# Issue Specific Hearing on the Draft Development Consent Order

21 February 2018, 10.00am

An Issue Specific Hearing (ISH) on the Applicant's Draft Development Consent Order (dDCO), its drafting, and its content.

### Drafting questions and issues relating to the draft DCO [APP-016]

LONG SECTION - FERRY ROAD
WORK NO. 9B

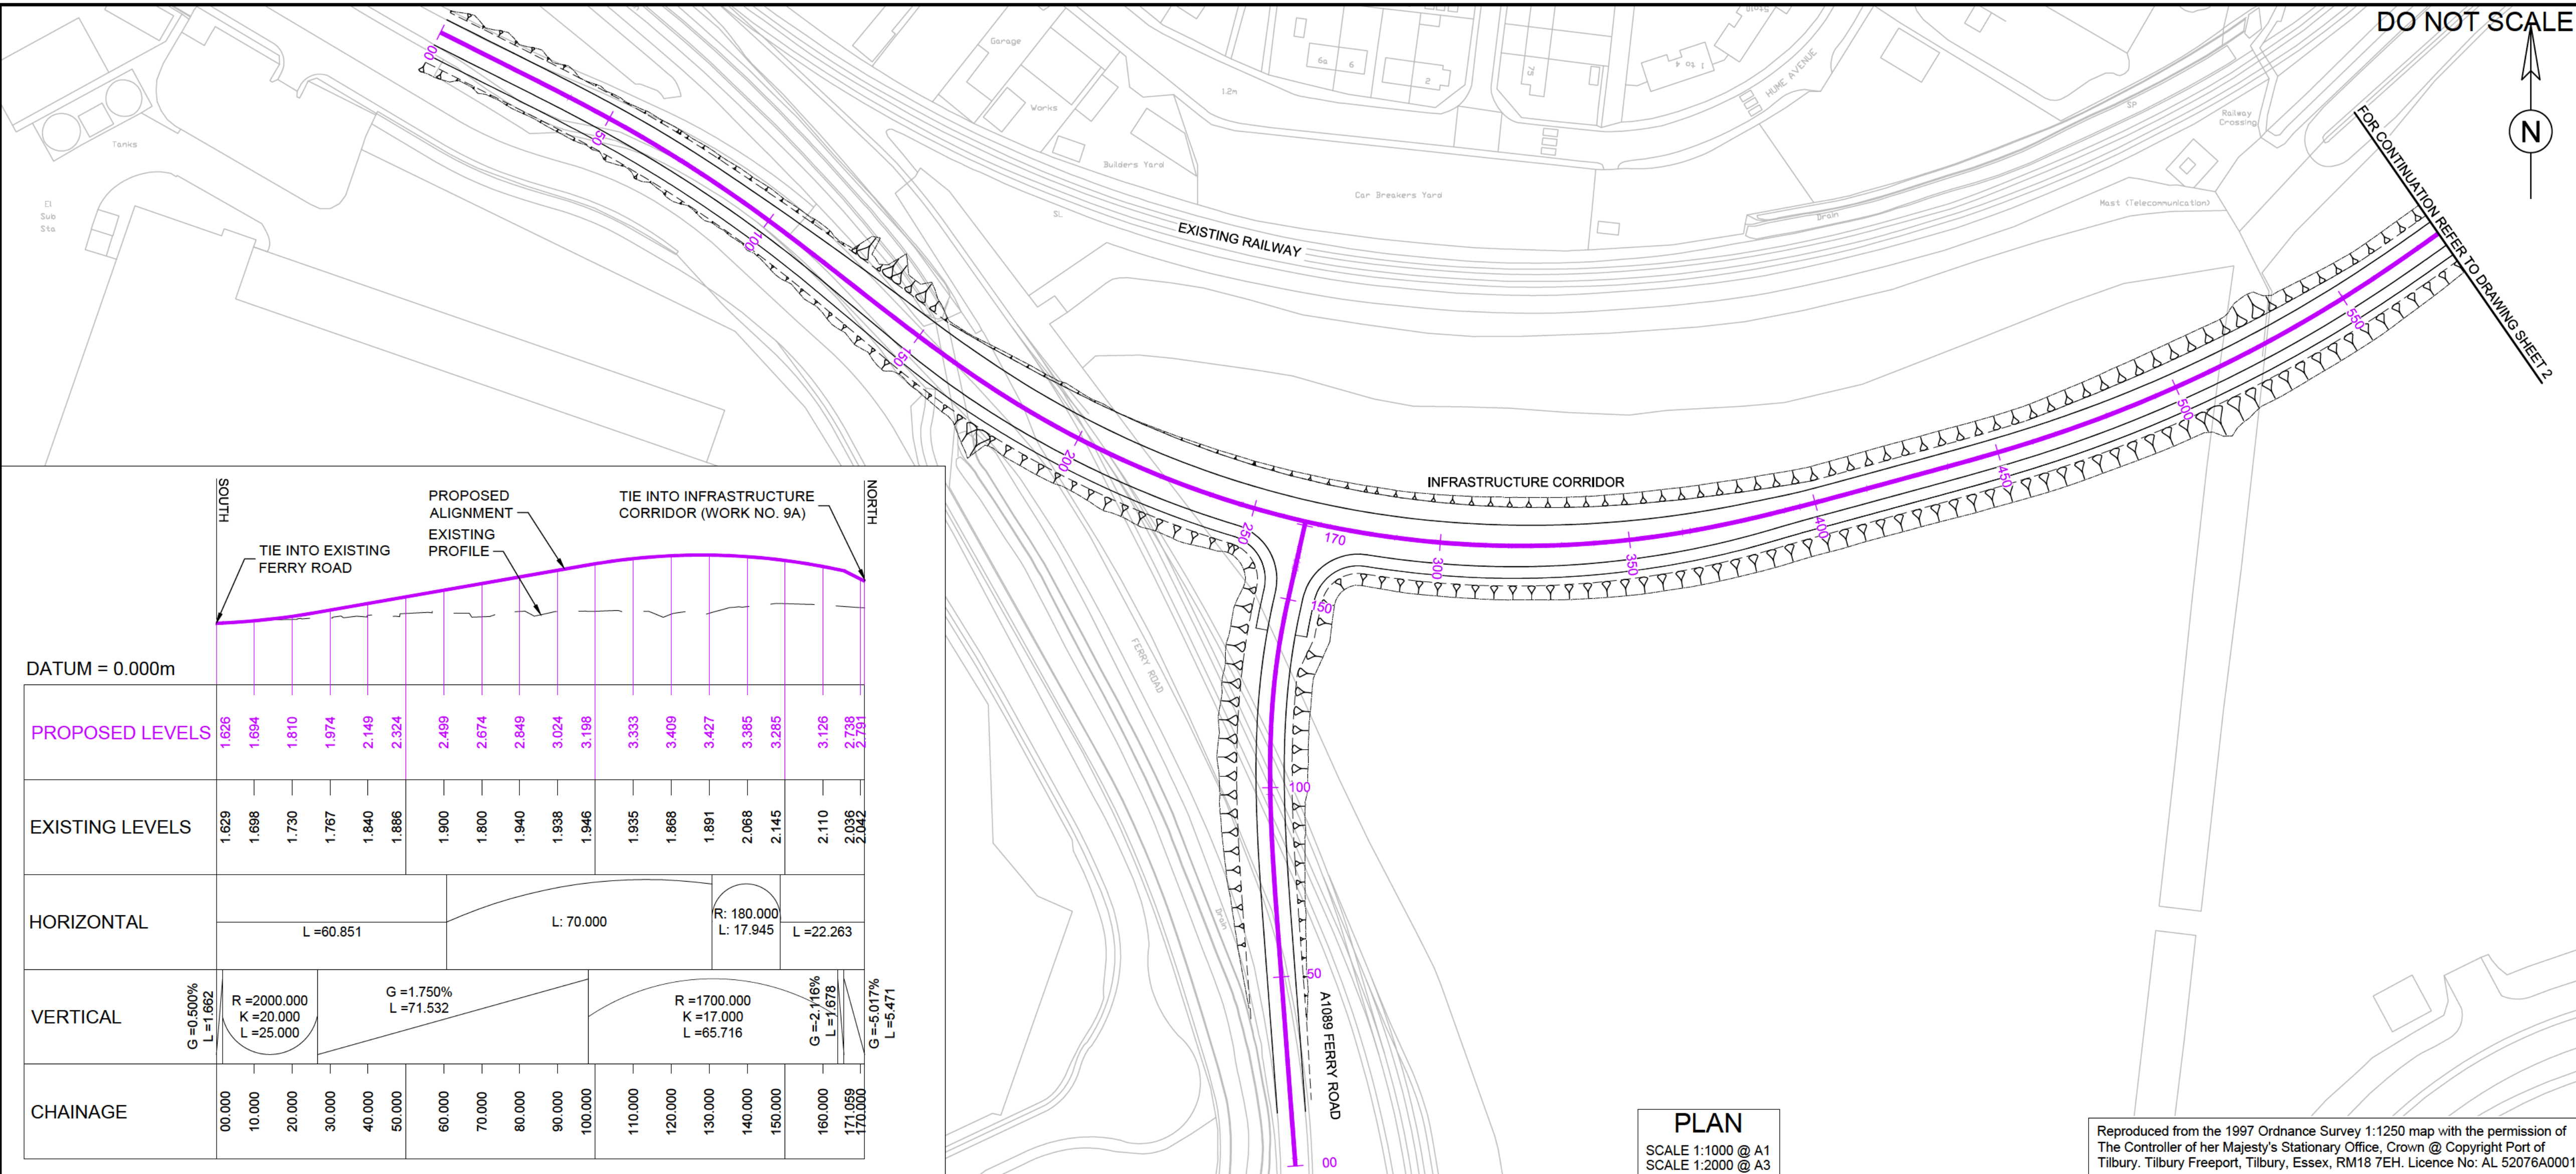
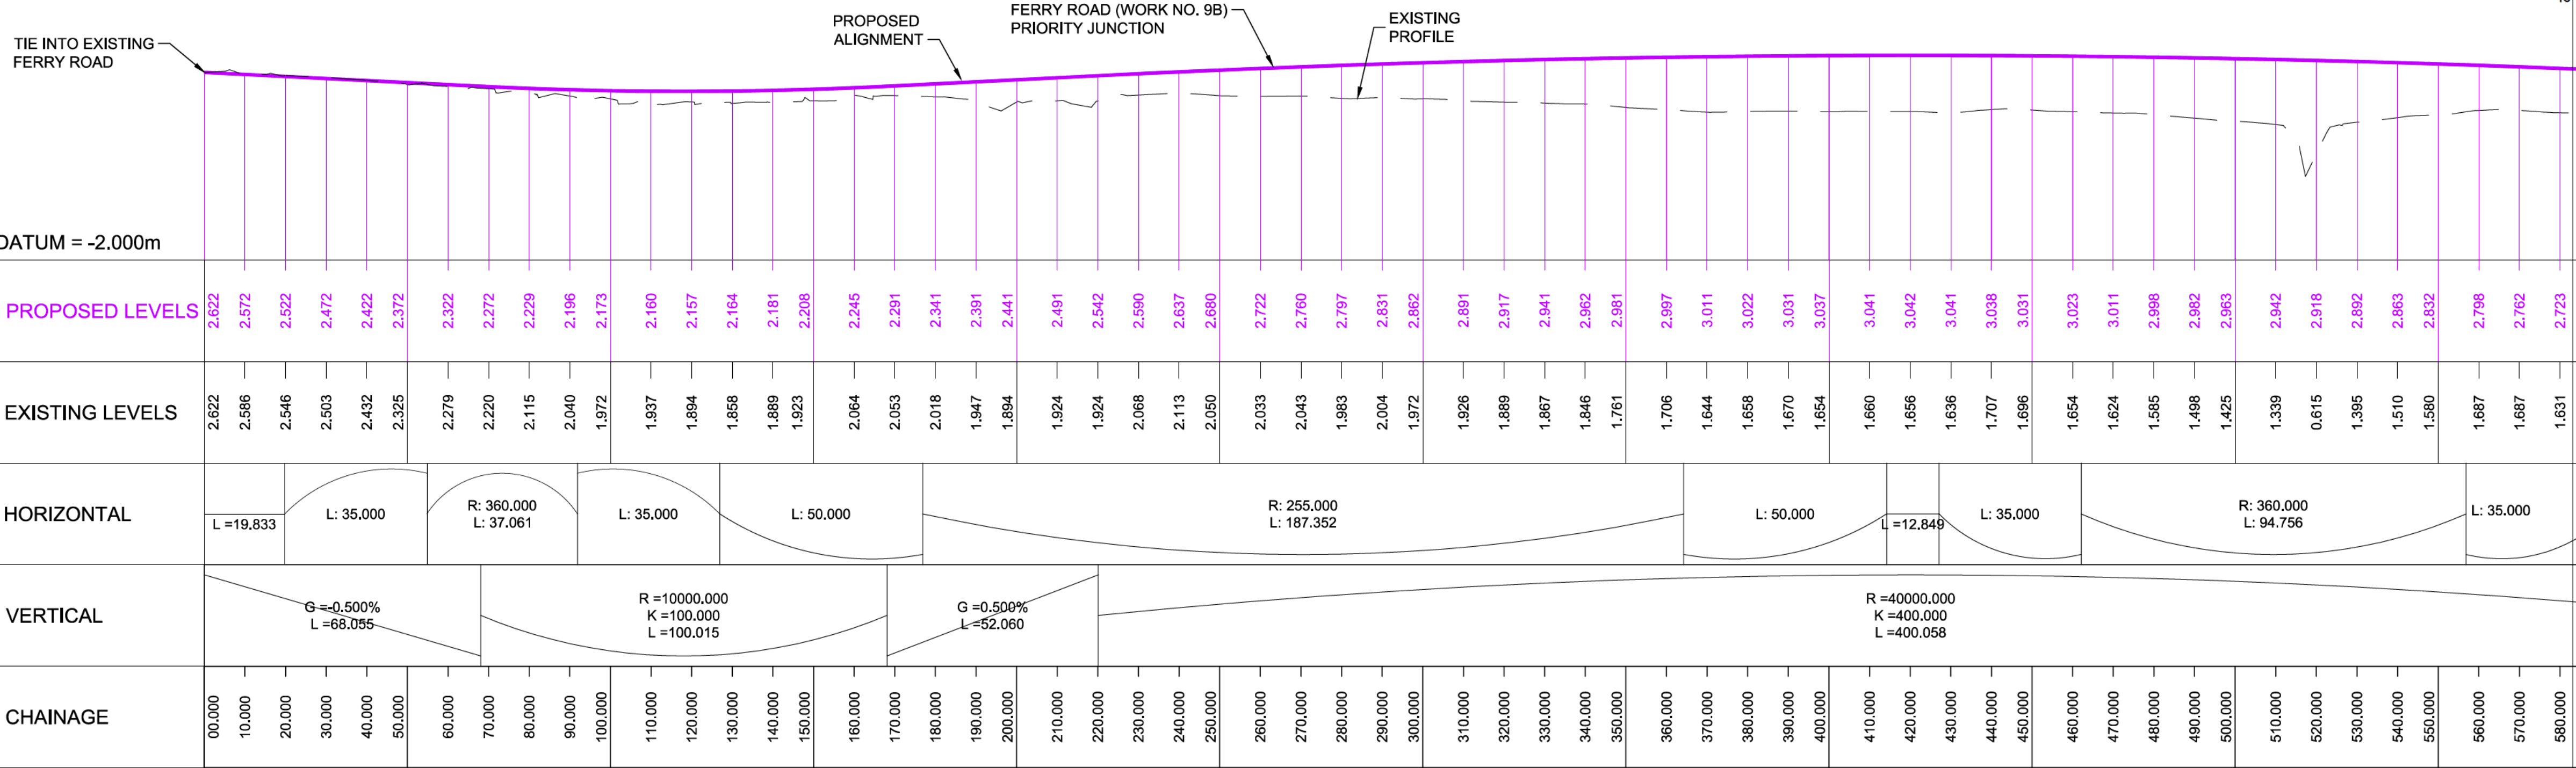
<b>Q No.</b>	<b>Part of DCO</b>		<b>Question</b>
			m) Does Works 9B cross the railway, if so is there any associated bridge construction necessary?
<b>55.</b>	<b>Schedule 1</b>	<i>Works No. 1</i>	<p>(a) This does not specify any particular piling method. How does the Applicant propose to restrict the methods of piling together with the types and dimensions of piles to those that were assessed in the ES?</p> <p>(b) This also includes the alteration and renewal of an existing flood defence. The Applicant's errata engineering drawings and plans [AS-010] included revised figures identifying the locations of the flood defences and necessary works, including a proposed flood gate. The proposed flood gate does not appear to be described in any of the Works in Schedule 1. Why not?</p>
<b>56.</b>	<b>Schedule 1</b>	<i>Associated Development</i>	Paragraph 6.38 of the ES [APP-031] states, " <i>However, as set out in the Outline Business Case, the development of land in the form shown is crucial to the future success of the project and PoTLL's investment objectives</i> ". Explain how this justifies the breadth of associated development provided in works 2-8, especially that of Works 8D(iii) with specific reference to paragraph 5 and 6 of the DCLG guidance <sup>1</sup> on associated development applications for major infrastructure projects.
